## 31 Fore St - Final Review Comments

Re: Final Review Comments for 31 Fore St. – Proposed Four Unit Building

DRIVEWAY APRON LAYOUT DETAIL
NOT TO SCALE

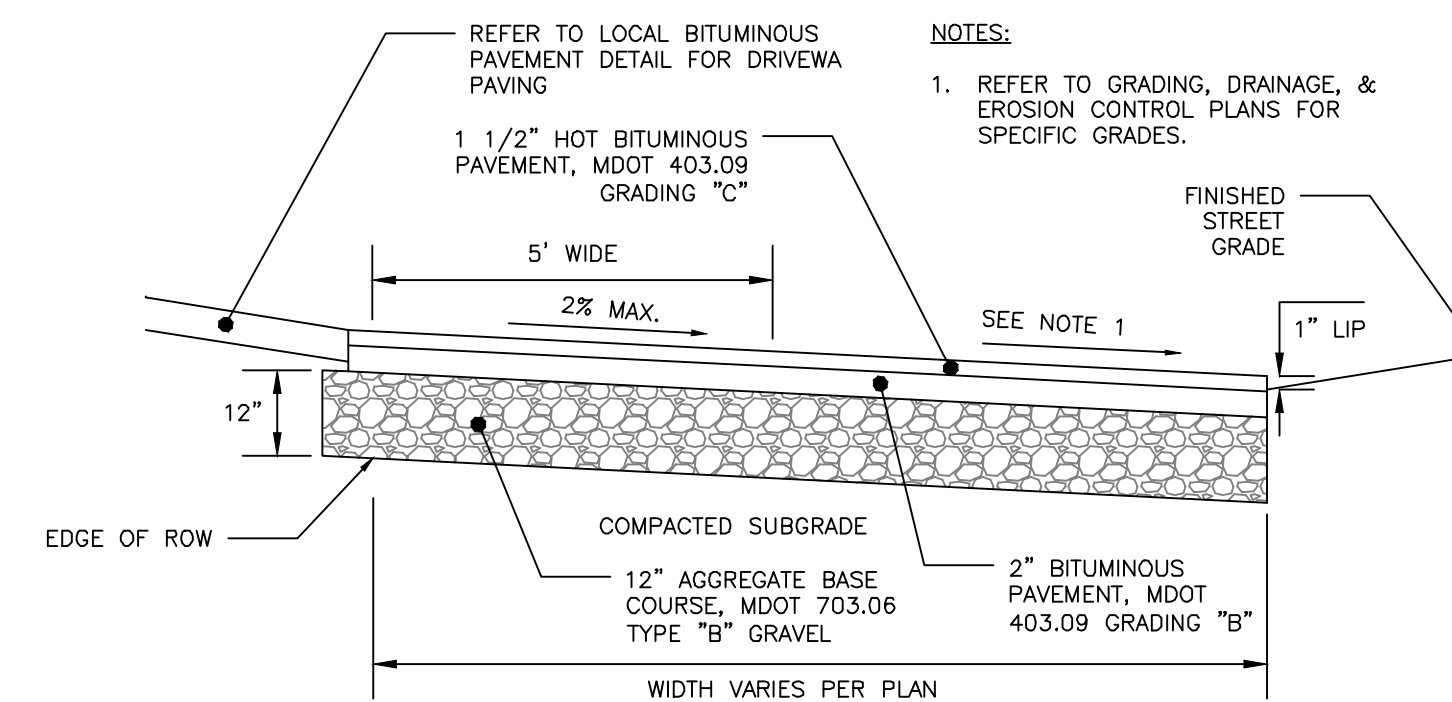
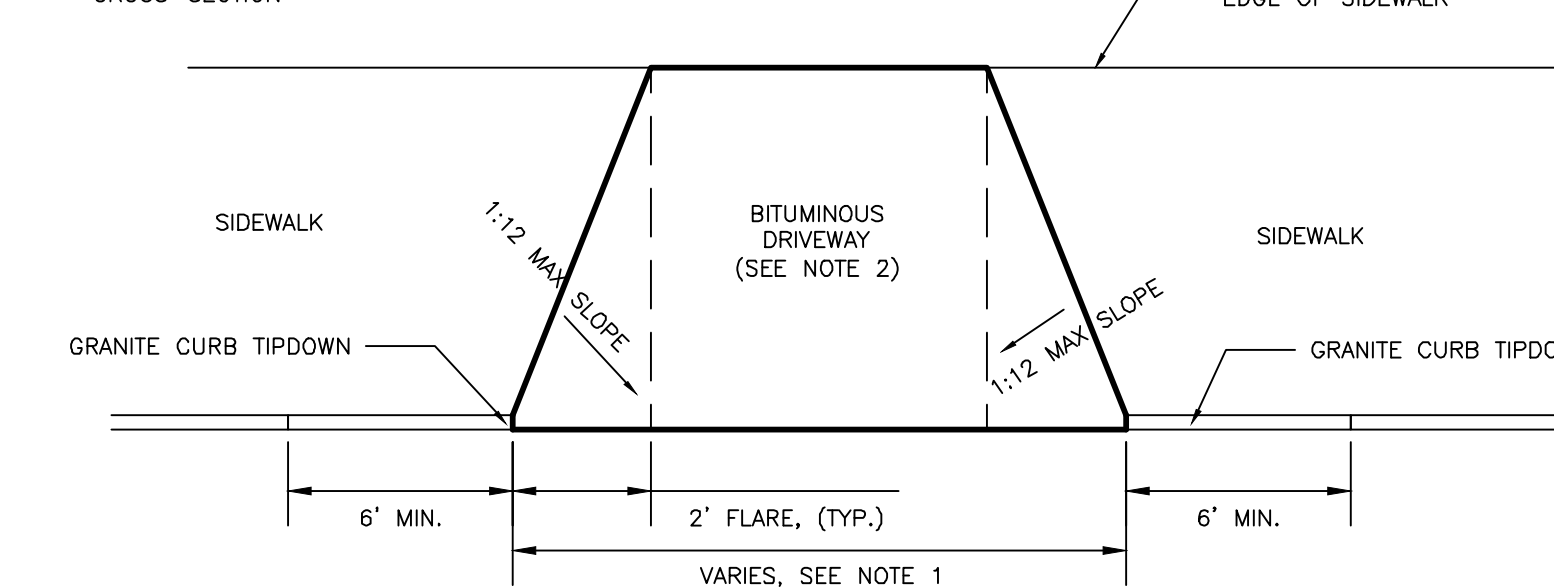
3. The proposed 12'-4" wide driveway on Waterville St. has an approximate 31' separation from the street corner as measured from the center of the drive to the street right of way (corner) of Fore St. Code requires 35'. Please try to make up the additional four feet by reducing the drive cut to 12', reduce the aisle width from 25'-8" to 24' and incorporate compact parking spaces (8' X 15') in an innovative manner.

**The applicant is request an approximate 3'-9" waiver of the required 35' driveway setback from the Fore St intersection. This Department is supportive of that waiver request.**
